NEPA/404 Merger Team Meeting Agreement

Concurrence Point 2A: Bridging and Alignment Review

Project Name/Description: US 1 Upgrade to Controlled Access Highway from I-540 to Harris/Purnell Road, Wake County, NC

TIP Project No.: U-5307

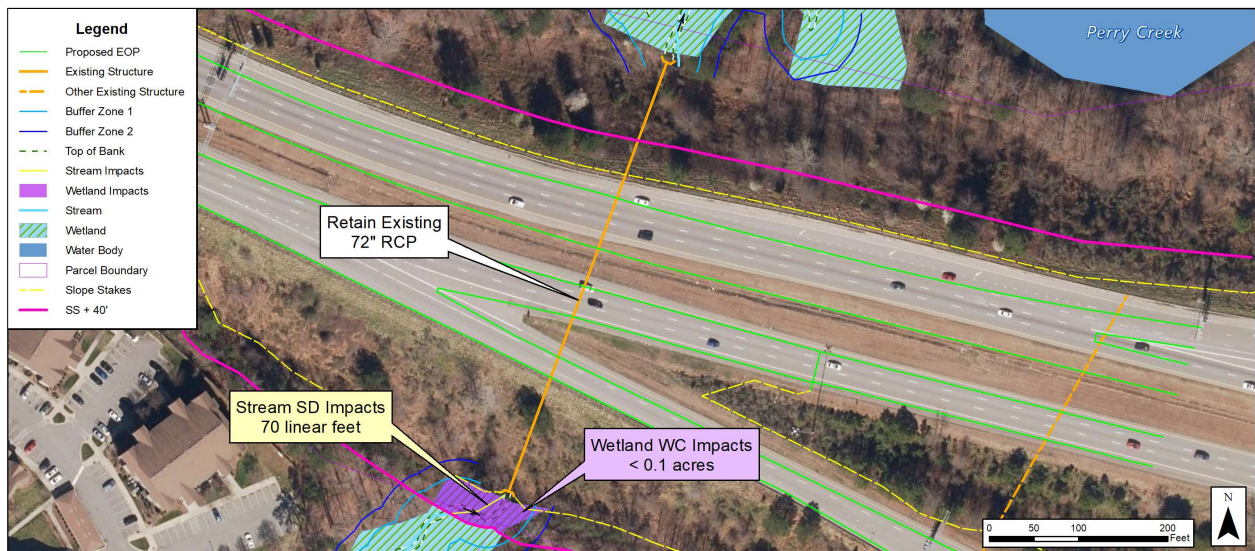
- USACE inquired about the three joints of existing culvert that would be replaced.
 - NCDOT Hydraulics responded that at this point there are no recommendations regarding existing RCP to be replaced. The current preliminary recommendation is to retain the existing culvert.

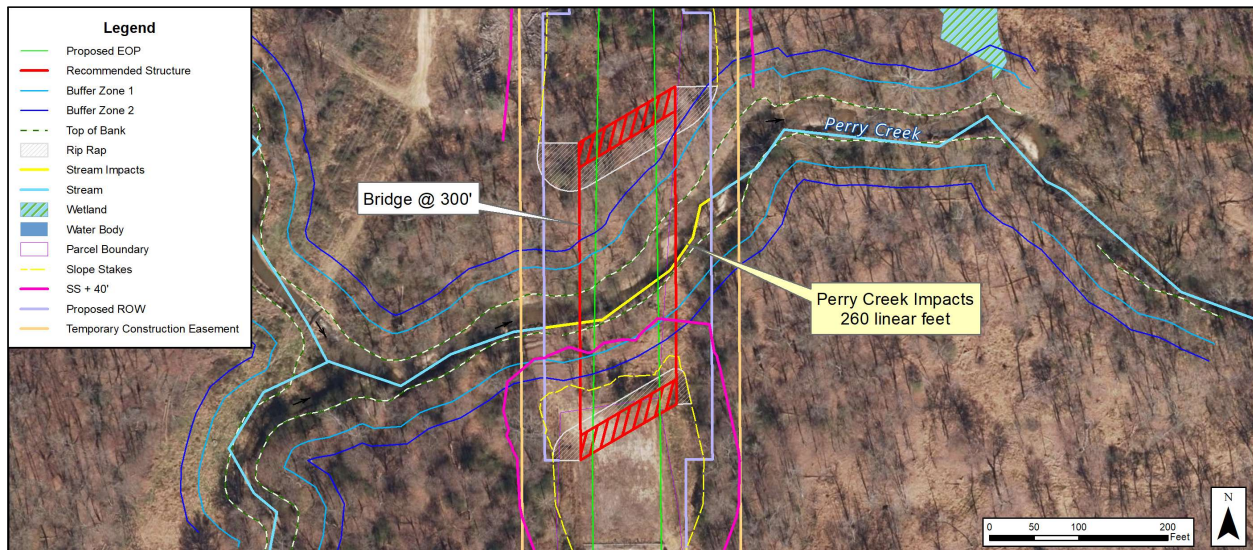
- USACE inquired if the anticipated impacts were for bank stabilization.
 - o RS&H clarified that for the purposes of this meeting, stream impacts were measured from proposed R/W lines.
 - o NCDOT added that if there are any impacts that they would be due to the bank stabilization.

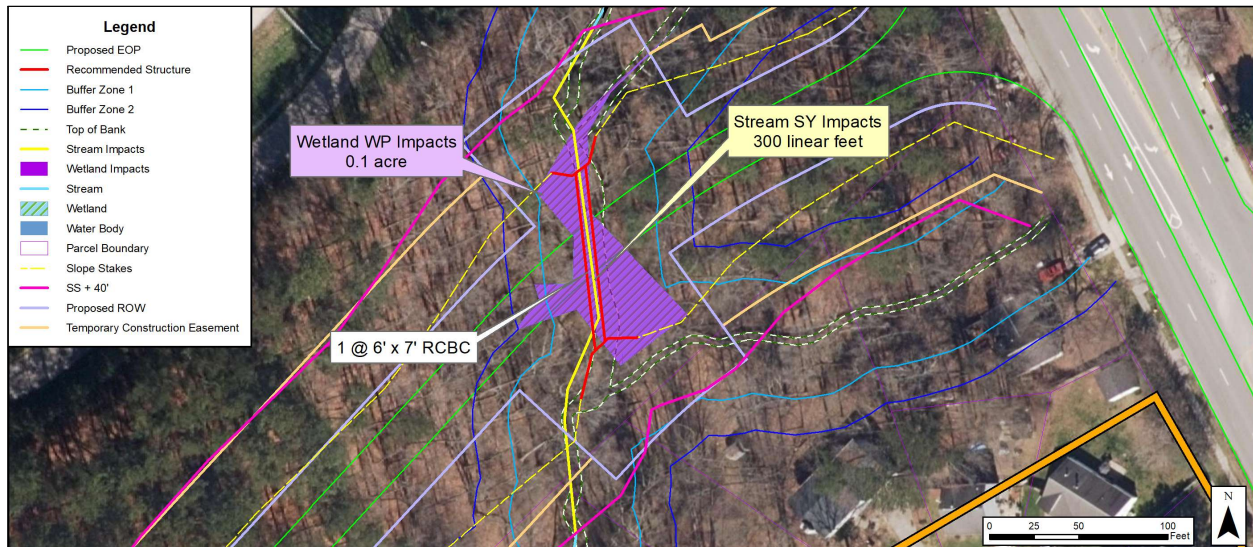
NCWRC requested notched sills to maintain the normal channel flow width. RS&H re-analyzed the hydraulic model and confirmed the culvert size as recommended is sufficient and meets the design year requirements with the new effective opening. The existing channel flow width is variable.

- USACE requested additional information on bridging options at this location.
 - Bridge with raised MUP (analyzed as potential cored slab at 48 feet wide)

- Total estimated construction cost plus mitigation costs for a bridge = \$462,000 + \$21,323.87 + \$117,754.65 = \$601,078.52.
- Mitigation ratios for impacted features will be revisited with USACE during permitting once final design is available.
- NCDOT still recommends a culvert instead of a bridge at this site due to the bridge being on a horizontal curve and issues with providing adequate sight distance prior to the intersection. Additionally, the drainage area is well below the threshold for considering a bridge, and the cost of a bridge at this location is almost double that of a culvert.

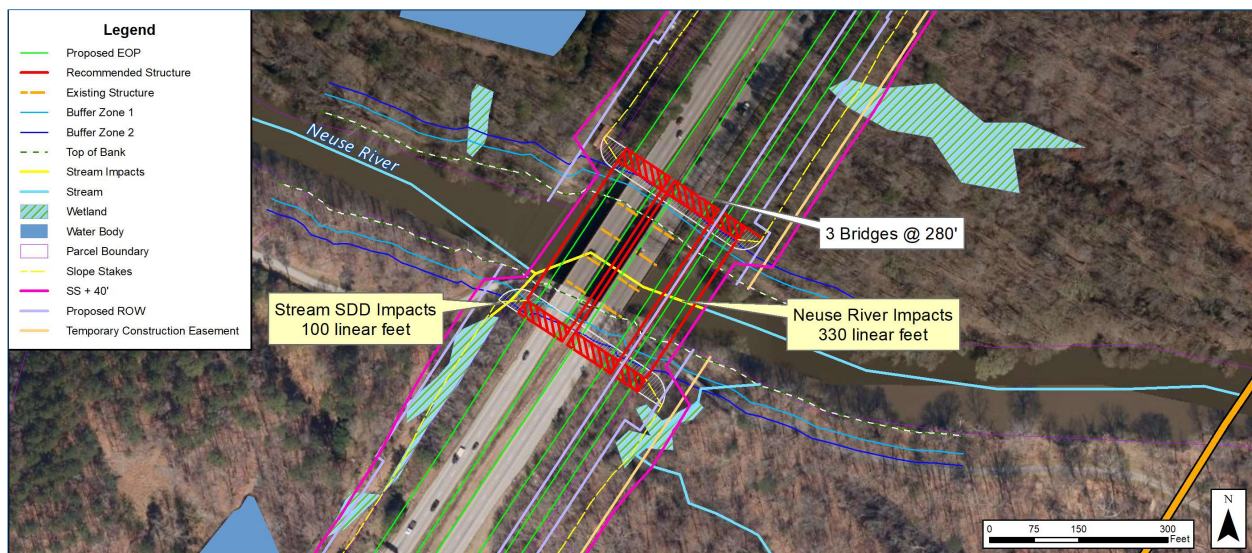
- Pam noted that the current design is providing approximately 40 feet from the top of bank and inquired what width of passage should be provided.
 - NCWRC responded that it is typical to provide a bank stabilization free section on riparian corridors and reiterated that US 1 is a barrier to wildlife.

- Alex added that providing a 100-foot total setback on the south side would result in a 370-foot bridge.
